9th December 2022

RE: Glanmire Solar Farm – Application Number SSD-21208499

In regard to the Exhibition of State Significant Development Application for the Glanmire Solar Farm proposed at 4823 Great Western Highway, Glanmire - Application Number SSD-21208499.

Glanmire Solar Farm
Indicative Site Layout Plan

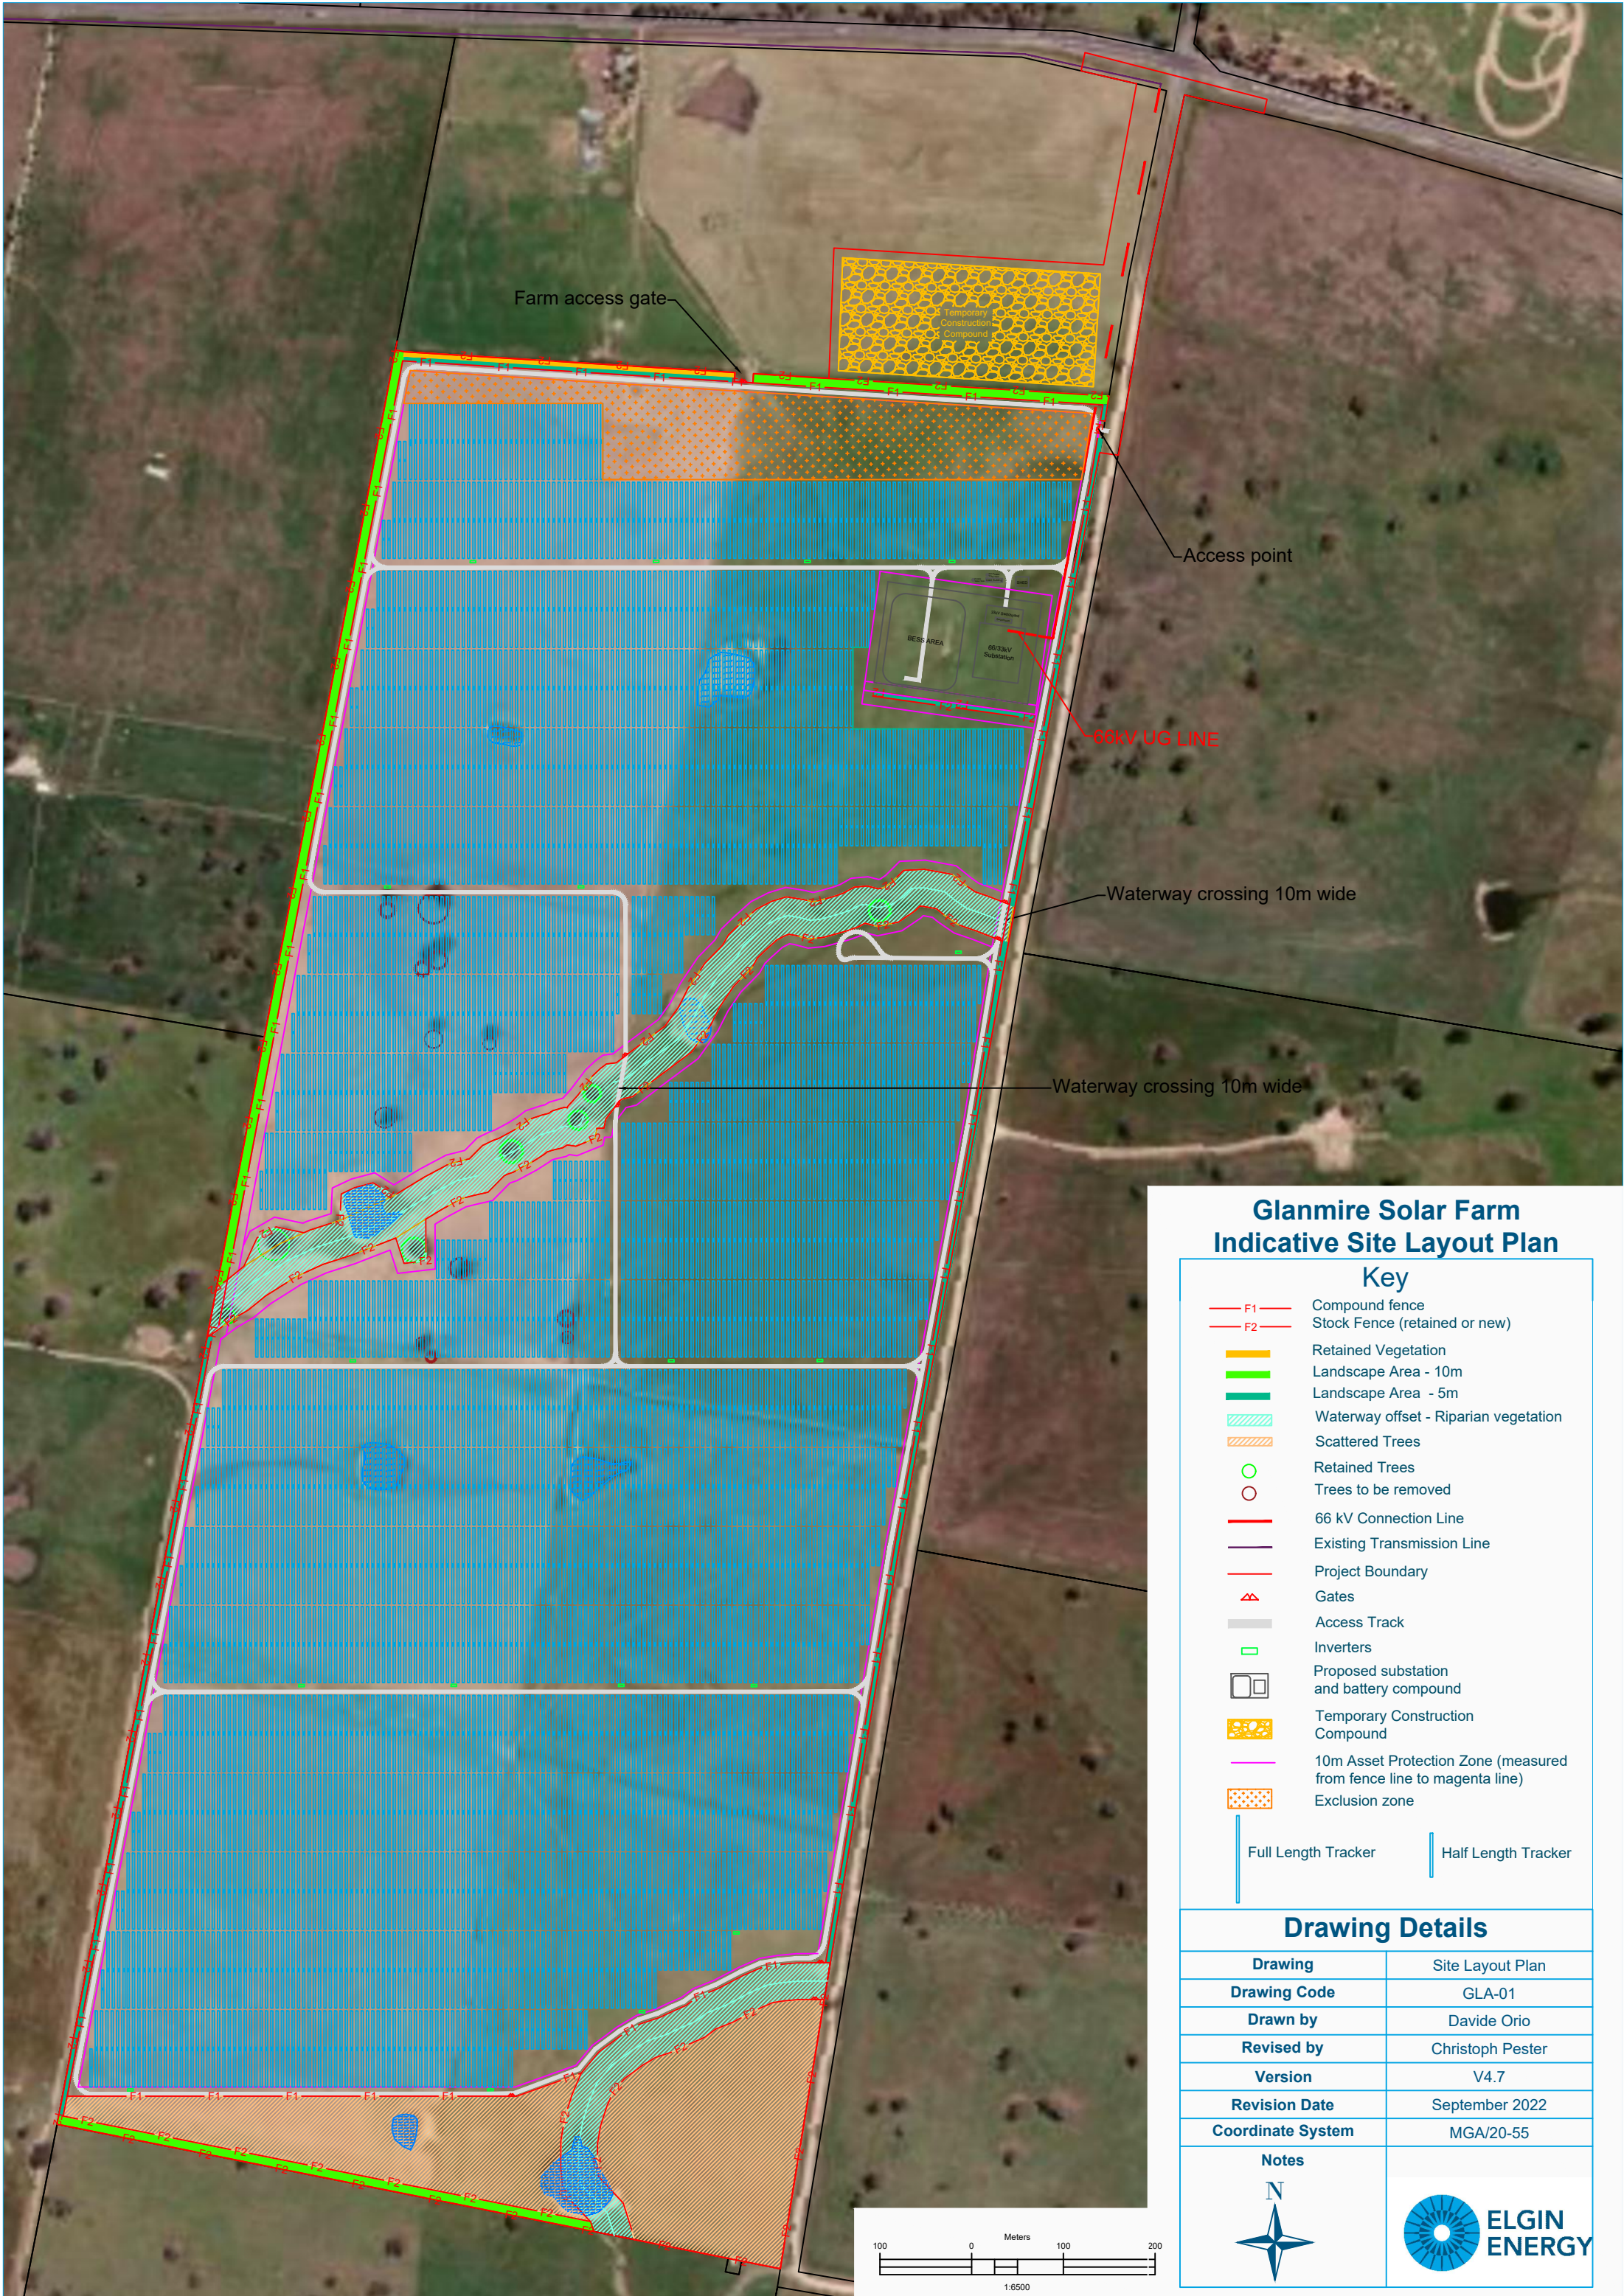
The EIS Indicative site layout plan shows that solar farm infrastructure is to be erected only 10 metres from the external boundary.

The solar farm infrastructure should be classified as either Farm Buildings or Rural Industry and a setback from the front, side and rear boundaries of at least 50 metres must be applied.

The EIS only considered the minimum 10m Asset Protection Zone (APZ) around the solar farm infrastructure in accordance with *NSW RFS Planning for Bushfire Protection 2019 - Part 8.3.5 Wind and Solar Farms*. This setback distance is hopelessly inadequate to mitigate a fast moving cured grassland or crop fire. Rather, in accordance with *NSW RFS Planning for Bushfire Protection 2019 - Part A1.3 Grassland Assessment*, where no Bushfire Safety Authority is issued or required, an APZ of at least 50 metres must be provided around the perimeter of the infrastructure.

It would be in the public interest that adjoining landowners be indemnified from damage to the solar farm infrastructure caused by bushfire or other natural hazard emanating from their properties, and the proponent maintains an APZ of at least 50 metres around the boundary perimeter to mitigate that risk in accordance with the appropriate guidelines.
